BRIDGECOR STEEL BOX
STERLING RANCH ROAD- CO SPRINGS
COLORADO SPRINGS, CO

Response to comments
in green

BRIDGECOR STEEL BOX
38'-1" SPAN X 11'-11" RISE
STERLING RANCH ROAD- CO SPRINGS
COLORADO SPRINGS, CO

BRIDGE PLAN

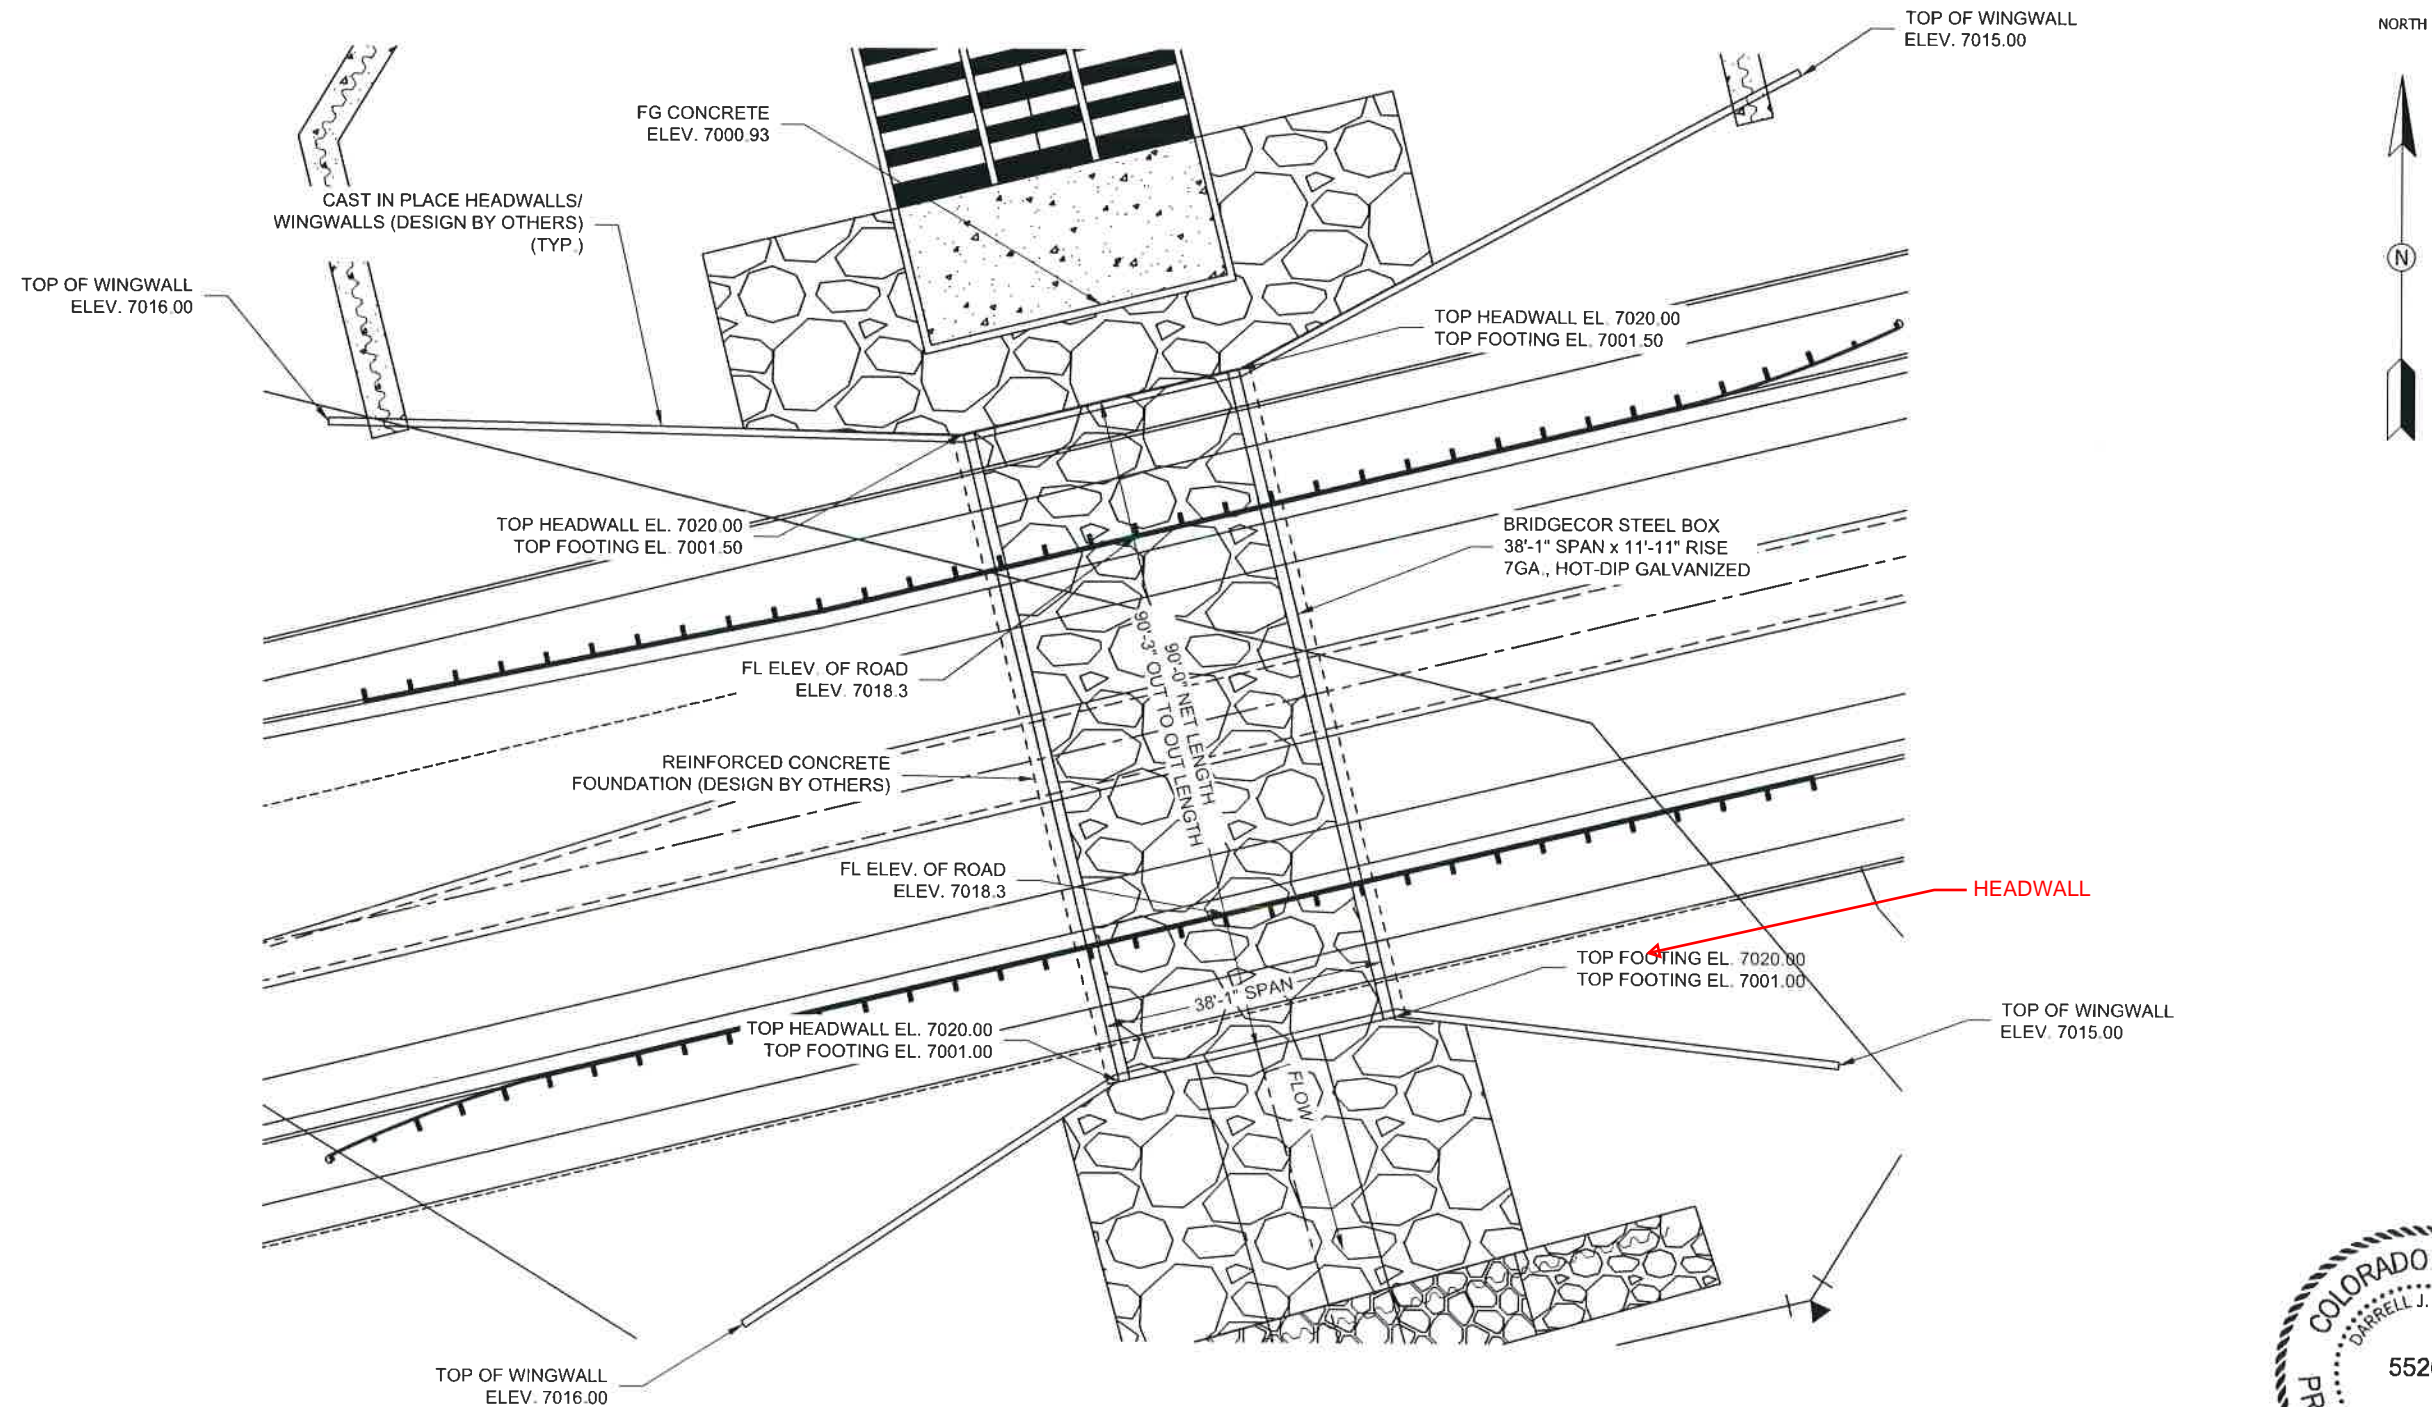
Provide plans, including all necessary appurtenances and elevations, cross-sections, and a longitudinal profile.

See revised plans set additional info. incl. longitudinal profile now included.
